CITY OF ALBUQUERQUE

RE: **Lot 35 Block 6 Unit 2 SAD 227**
7904 Kibo NW
Volcano Cliffs Subdivision
Grading and Drainage Plan
Engineers Stamp Date 1/22/19 (E10D056)

Based upon the information provided in your submittal received 1/23/19, this plan cannot be approved for Grading Permit until the following comments are addressed.

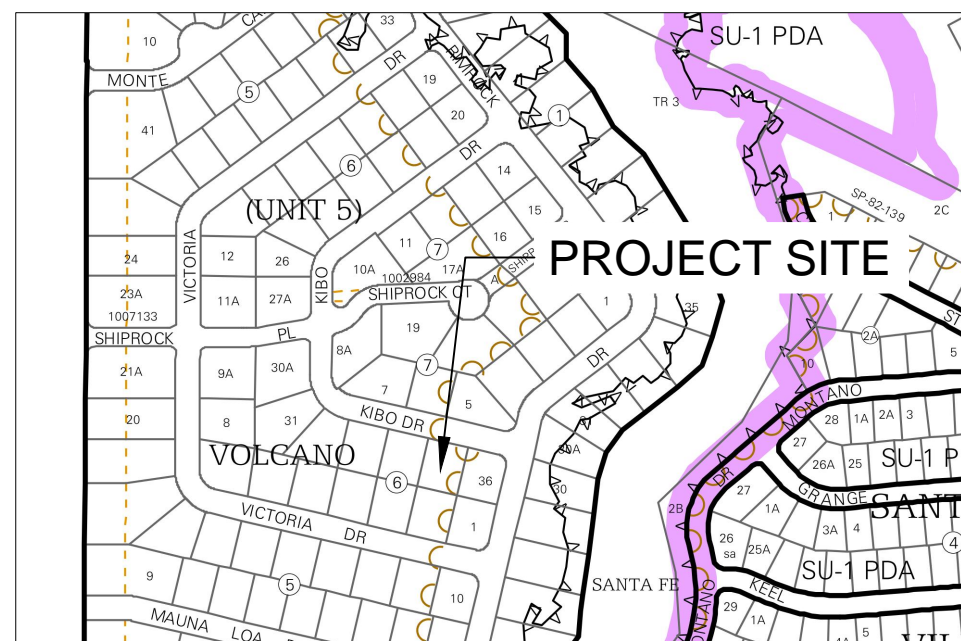
- Provide a section of the NE corner showing how the flows will drain to Kibo Ave. or a pond which will hold the 100 year 10 day volume.
- Provide the easement on the west side of the property.
